***Adaptive Reuse of the Clare Hotel and
Administration Building on Block 3A***

***Central Park, Chippendale
(Former Carlton United Brewery)***

MP 11_0089 - Modification 1

Director-General's
Environmental Assessment Report
Section 75W of the
Environmental Planning and Assessment Act 1979

PROPOSED GFA = 33.8sqm

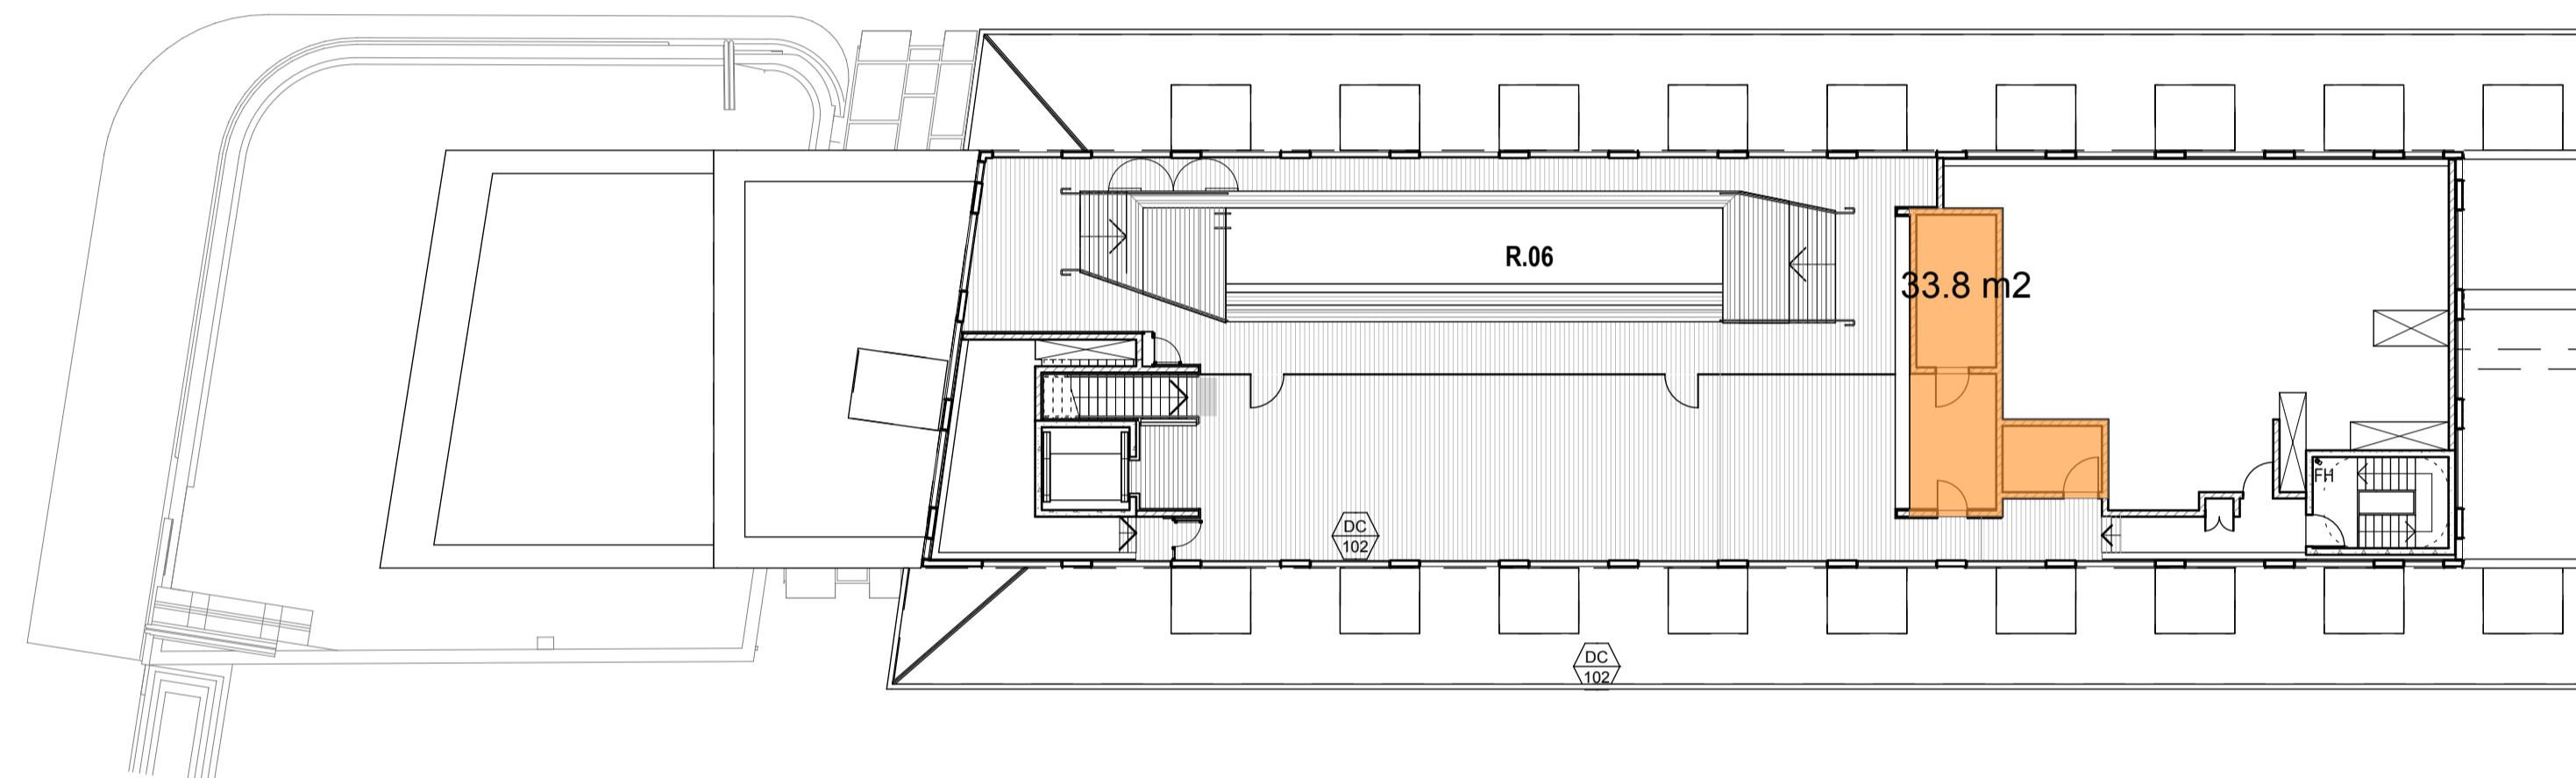
The proposal seeks to increase the GFA of food and drink premises from 1,098m² to 1142.8m² (an additional 44.8m²) without amending the total approved GFA (4,595.9m²). The increase in the food and drink GFA of 44.8m² has arisen as a result of internal design amendments to each level throughout the Clare Hotel and Administration building. **Table 1** shows the change in GFA allocated on each level of both buildings.
